**Reviewed by:  
Glenn Reese, P.E.  
Stormwater Engineer I  
glennreese@elpasoco.com  
719-675-2654**

**SMALL SUBDIVISION FINAL DRAINAGE REPORT  
FOR  
CLOVERLEAF FILING NO. 1**

**December 1, 2020**

**Add text:  
PCD Filing No.: SF-21-014**

PROPOSED DRAINAGE MAP

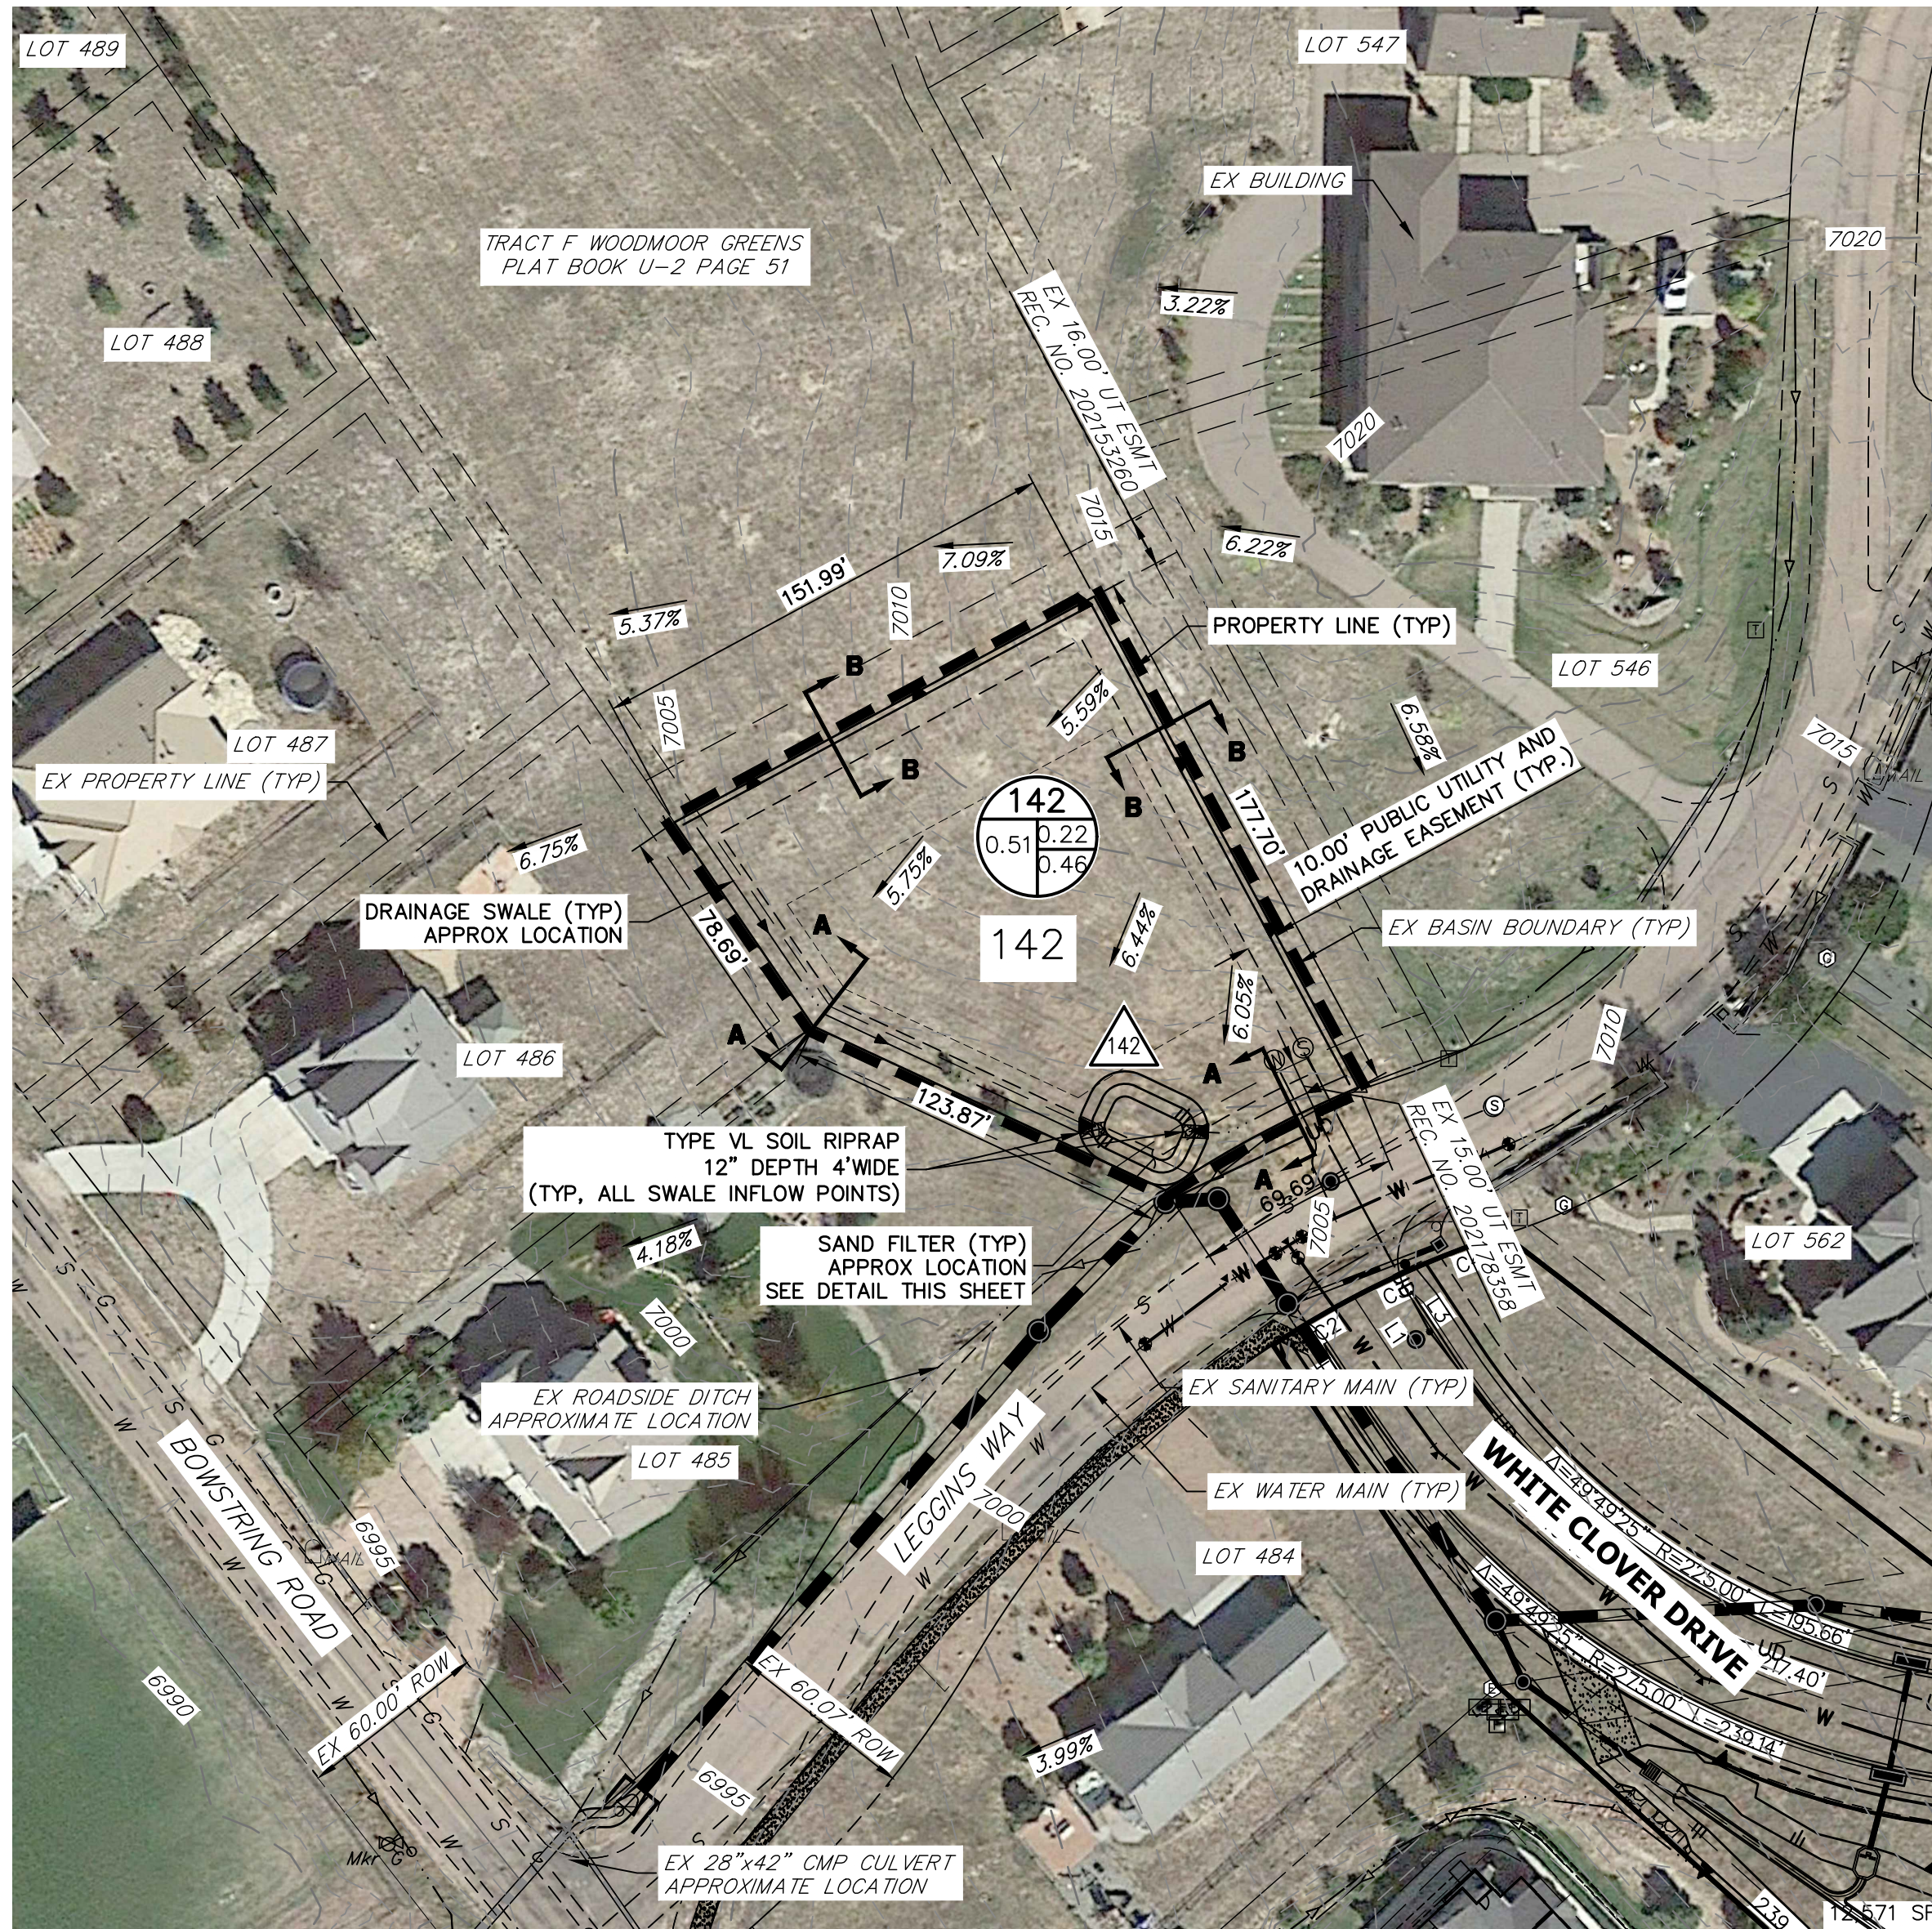
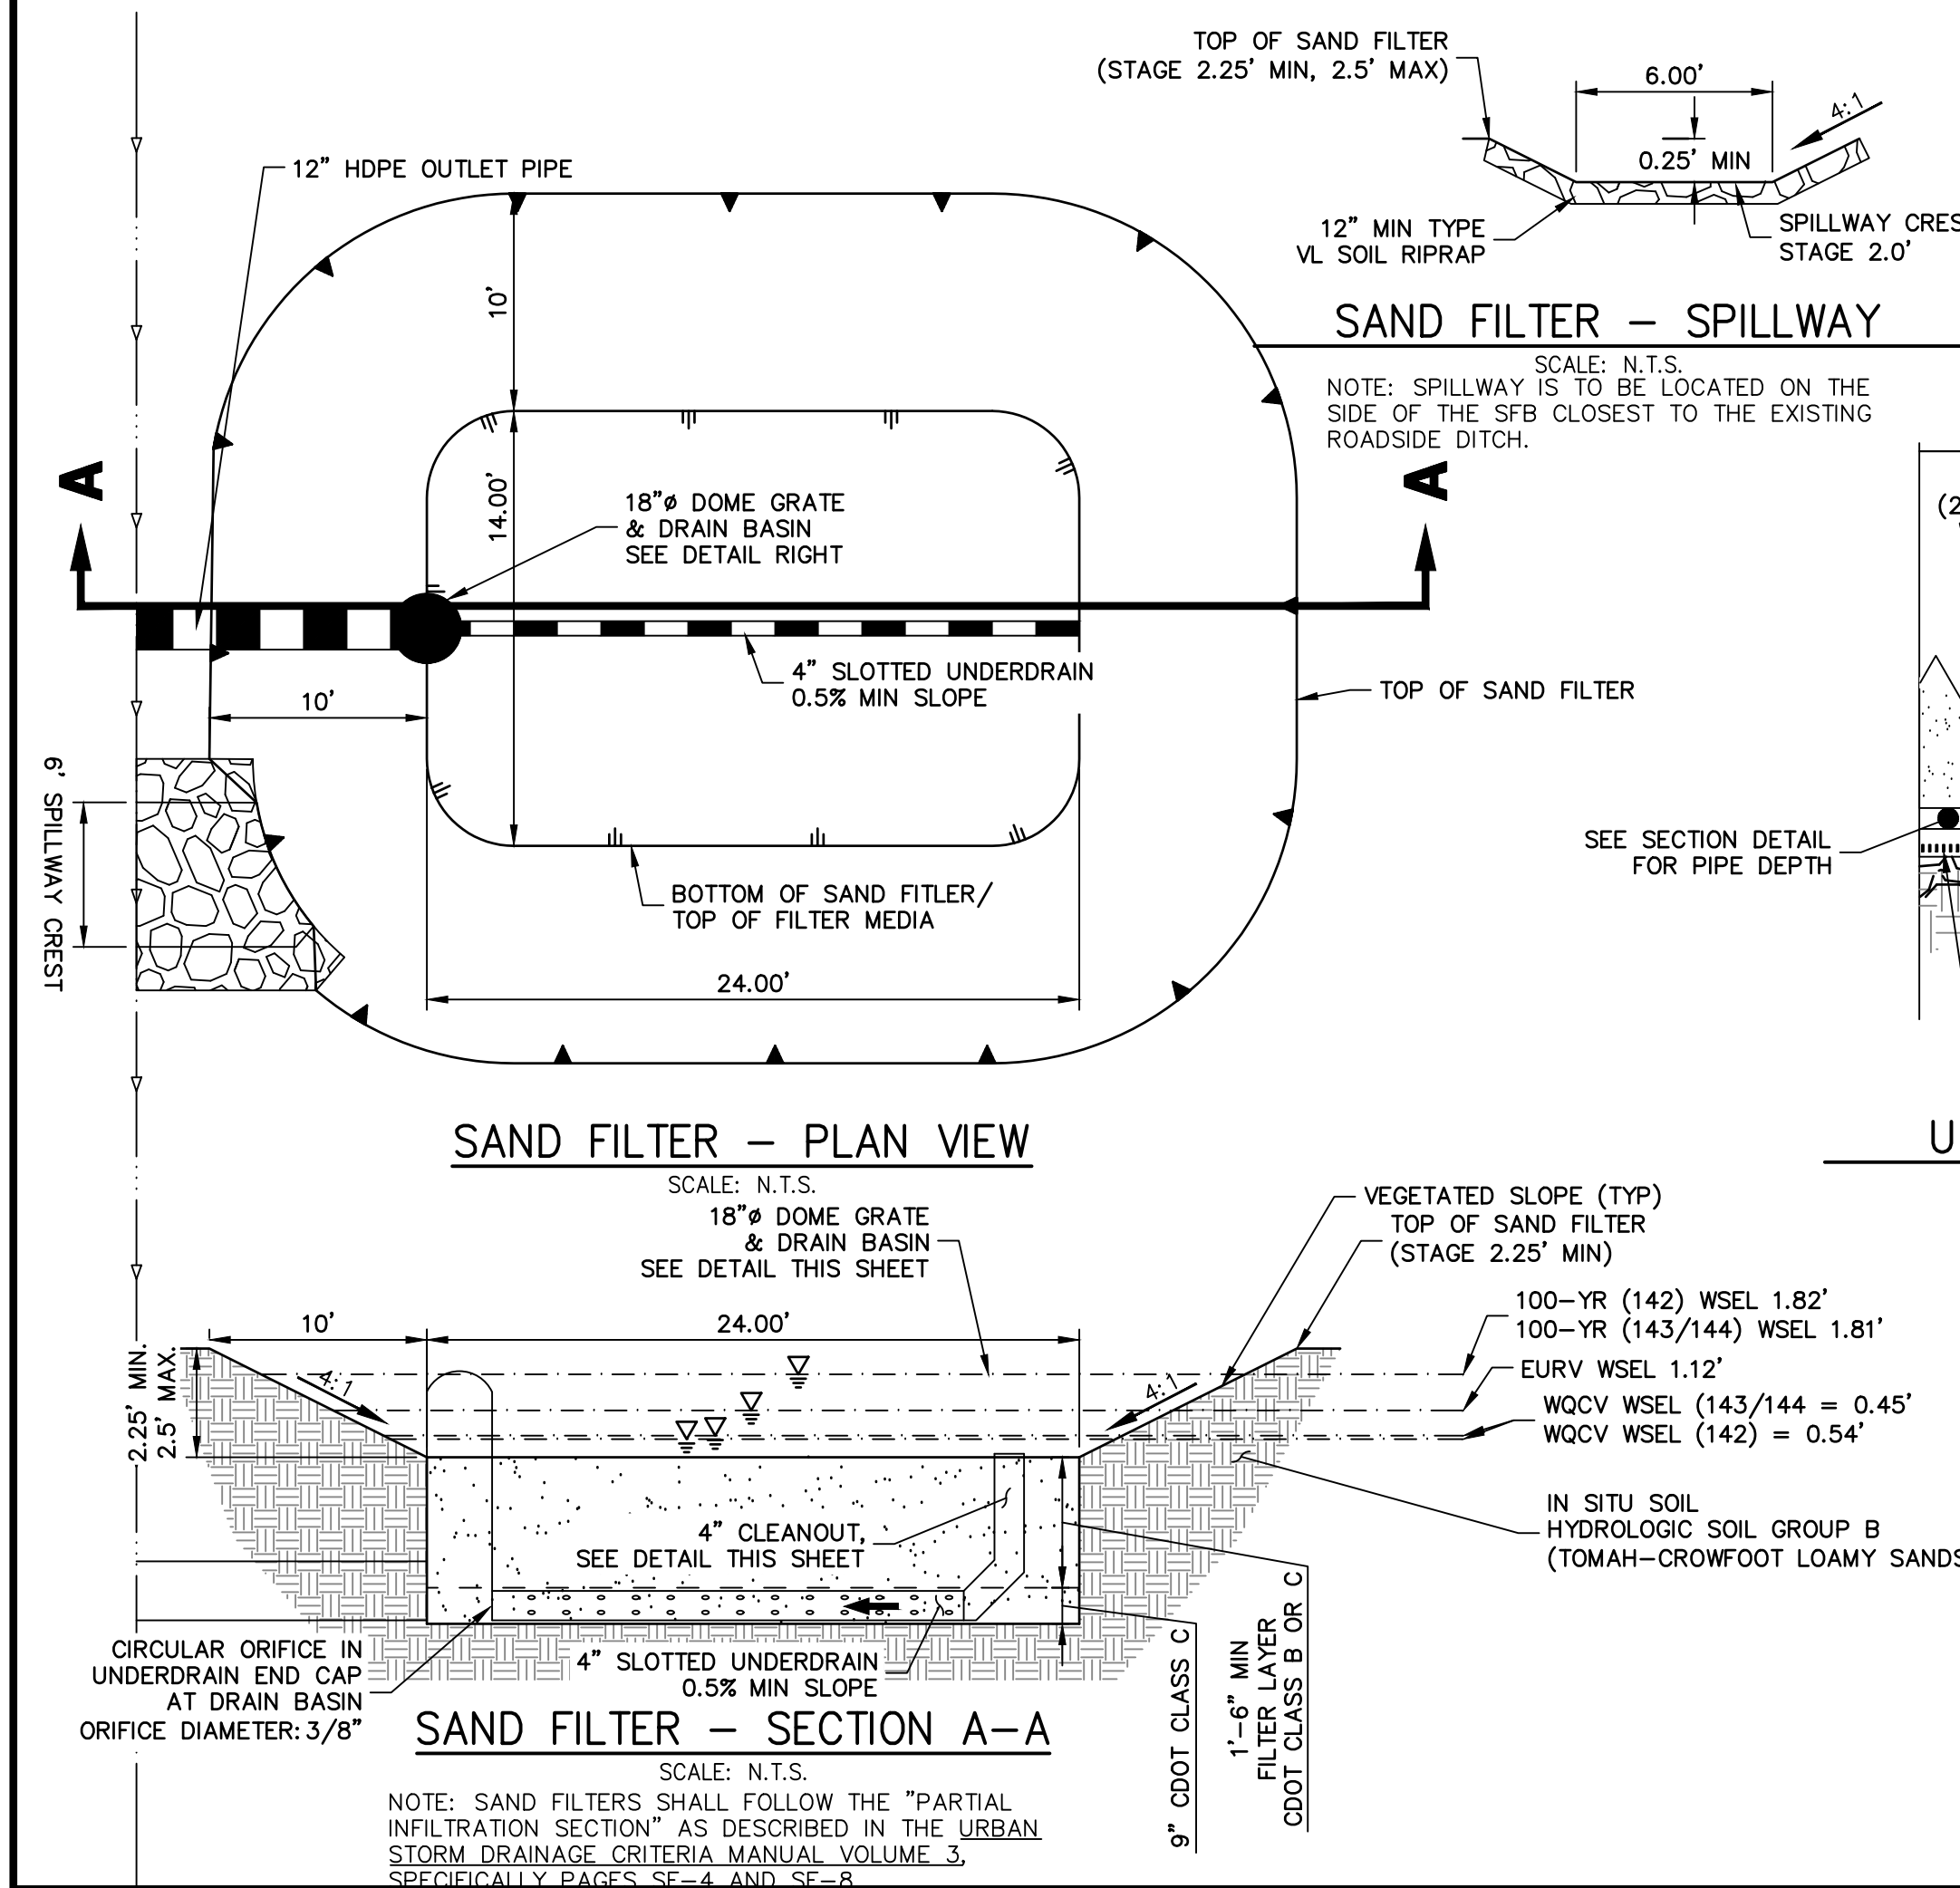
Please explain how. Is there a berm around the property to prevent offsite flow from entering the site? It looks like the land to the east of lots 143 and 144 flows onto these lots.  
If needed, include tributary basins into the rational method calcs in Appendix B
